CITY OF ALBUQUERQUE

December 21, 2012

Re: Broadstone Cottonwood or 528 Apartments, Conceptual Pond Regrading Information

Engineer's Stamp dated –no stamp-(A13/D022)

ENGINEER'S SEAL	DRAWN BY	
		DY	
		DATE	
		8/01/13	
BROADSTONE COTTONWOOD		2011043-G&D	
OVERALL GRADING AND DRAINAGE PLAN		SHEET #	
TIERRA WEST, LLC		GR-1	
5571 MIDWAY PARK PLACE NE		JOB #	
ALBUQUERQUE, NM 87109		2011043	
(505) 858-3100			
www.tierrewestllc.com

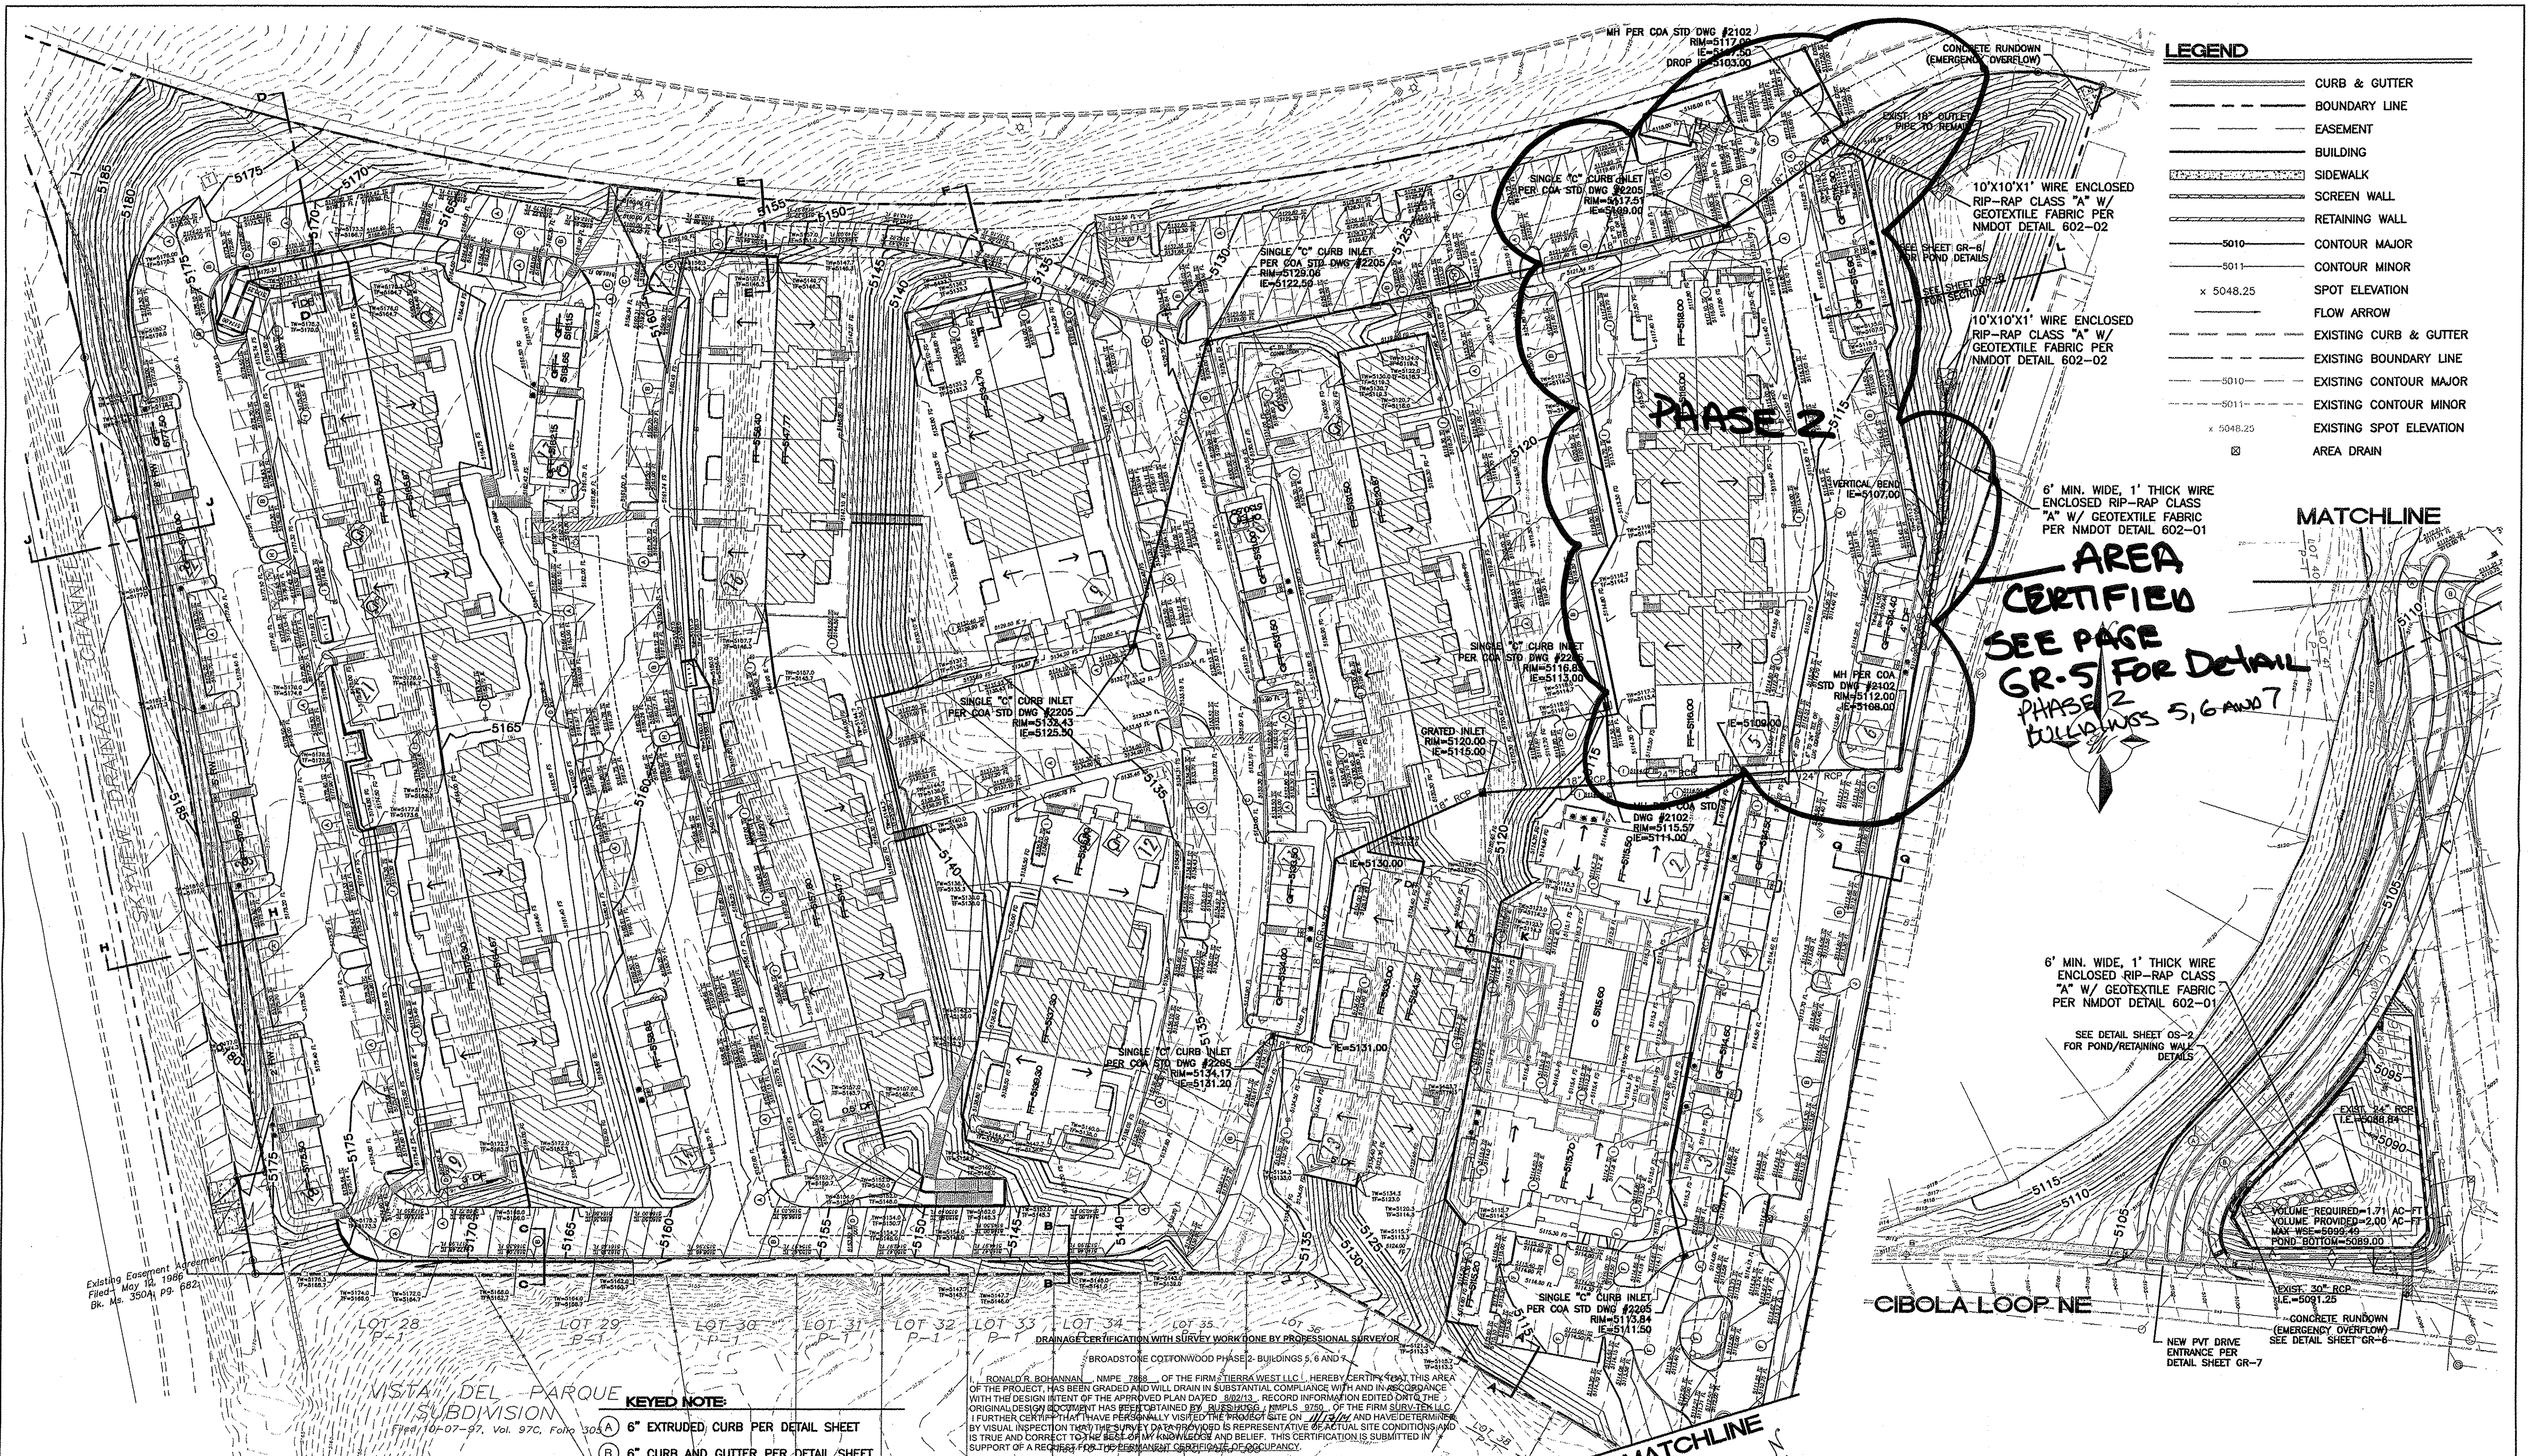
- At the southeast corner of the pond, the proposed WSE is approximately 3 feet higher than the street. Alternatives provided below to lower the WSE are to be examined and conclusions provided prior to proposing a perched pond. Hydrology's concern is that if the berm fails, this could send a 3' tall surge of water down the street or into the apartment complex.

- Proposing one retaining wall rather than two would lower the WSE.
- Shifting the access road west and building a retaining wall west of the road would lower the WSE.

- Reducing the road width would lower the WSE. Are an 8 foot wide median and 12 foot wide drive lanes necessary?
- Other alternatives that may lower the WSE.

- Walls in the pond shall be flood walls; continuously poured concrete, not CMU and be built up to the WSE. A compacted earthen berm can be constructed over the floodwall between the WSE and the required freeboard, 1 foot.

- From the drainage report for the Vista Del Parque Subdivision (A13/D2), the required pond volume is 1.43 ac-ft. The proposed volume is 1.33 ac-ft.
- Provide a section of the pond near the southeast corner of the pond that shows the existing curb on Cibola Loop as well as a section of the pond including the access road at the apartment site to the east. Section should be near the southeast corner of the pond.

- Why was an ID 11.75 inches used in the orifice equation, when the outlet pipe has an ID of 24 inches (CPN 5752.81)?
- It is an unusual situation that an Administrative Amendment will require public infrastructure to be built by Work Order. The normal process is for the public infrastructure to be financially guaranteed or built and accepted prior to site plan or plat approval. This has been discussed with the engineer as well as the City Engineer.
